RE: BAIADA INTEGRATED POULTRY PROCESSING FACILITY (SSD-9394)

ATTACHMENT A

Additional Information Required to Inform EPA Assessment of Baiada Integrated Poultry Processing Facility

Figure 11 | Odour Contours

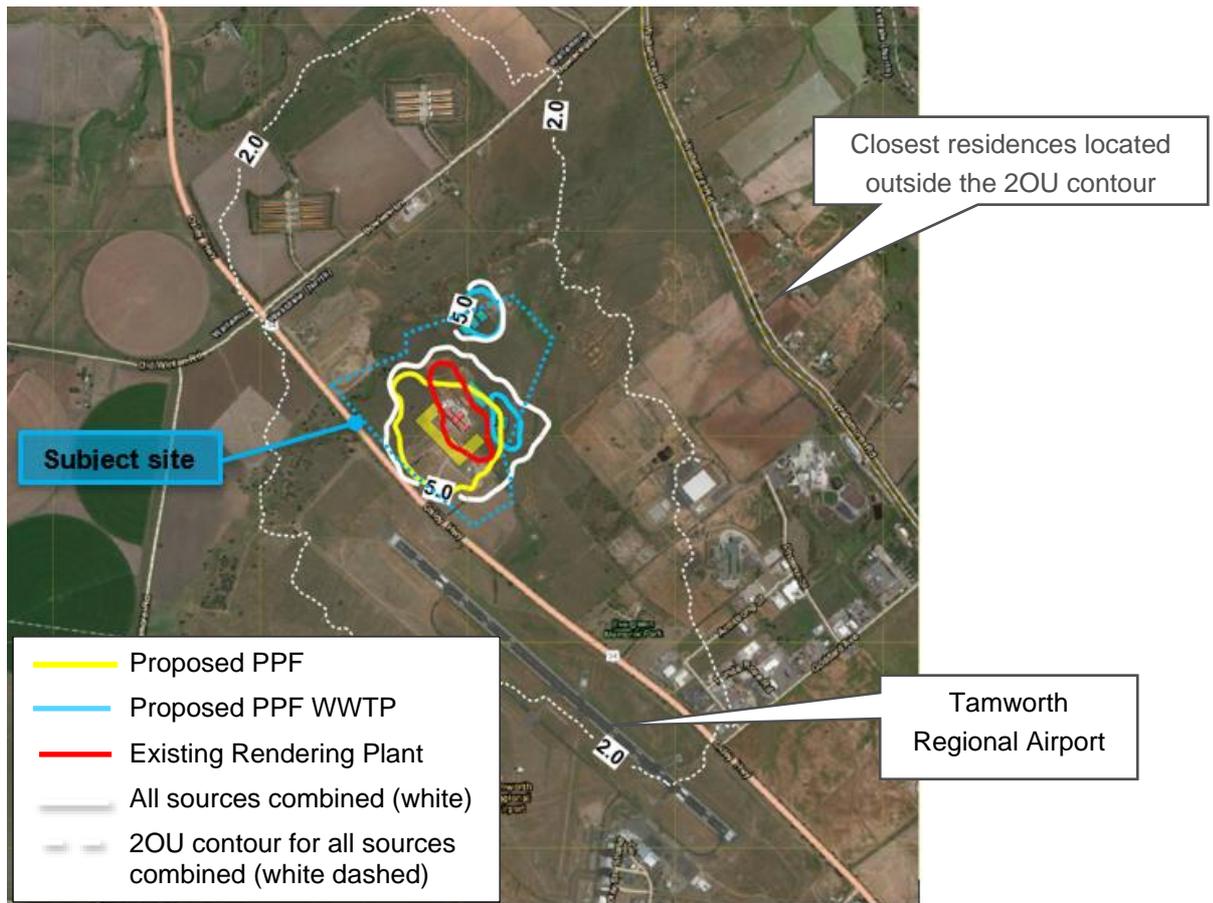
The AQR has not adequately demonstrated that it has used the correct odour assessment criteria for the potential affected population, including the childcare centre and Tamworth Regional Airport.

The AQR needs to be revised to include a 2 OU contour. The odour assessment criteria must then be based on the population within that 2 OU contour, including maximum capacity of the childcare centre. The maximum capacity of the Tamworth Regional Airport should be considered if it falls within the 2 OU contour.

Figure 15 | Acoustic barrier locations

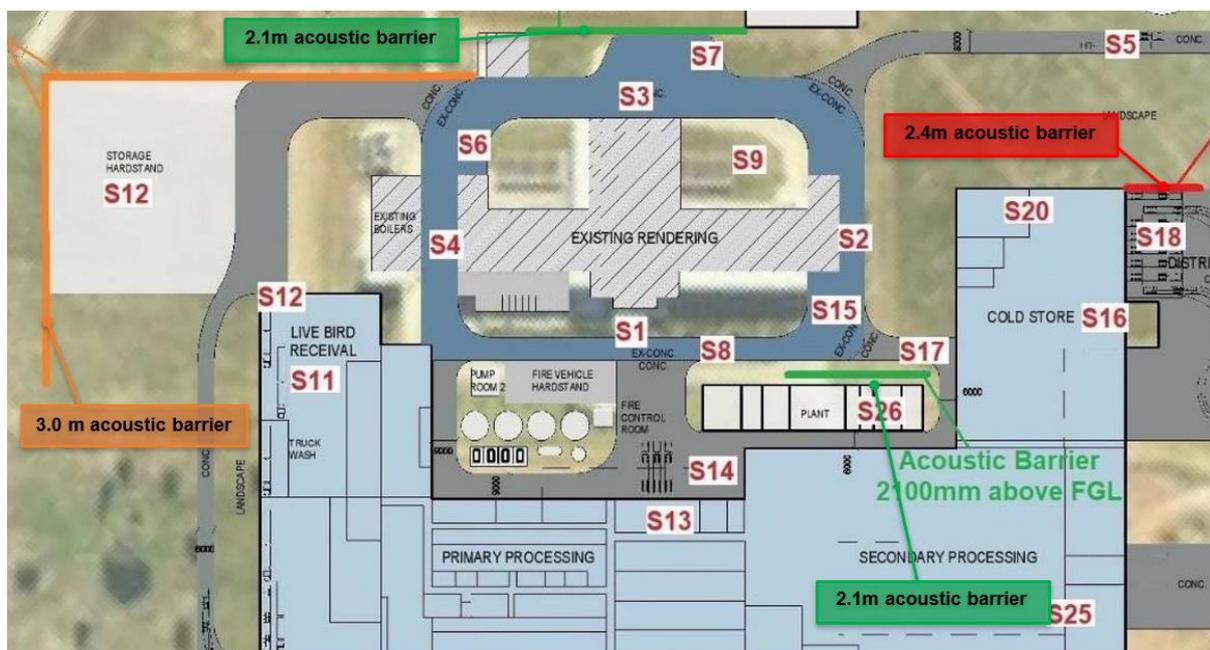
- The acoustic report has not considered the possibility of tonal aspects from the mechanical plant and equipment which has the potential to add a 5 dBA penalty to the noise level at the receiver. If tonal characteristics are present this would likely result in non-compliance with the Project Noise Trigger Levels at most locations during the evening and night periods. As such, any potential tonal or low frequency adjustments must be made addressed in accordance with Fact Sheet C of the NPfl.
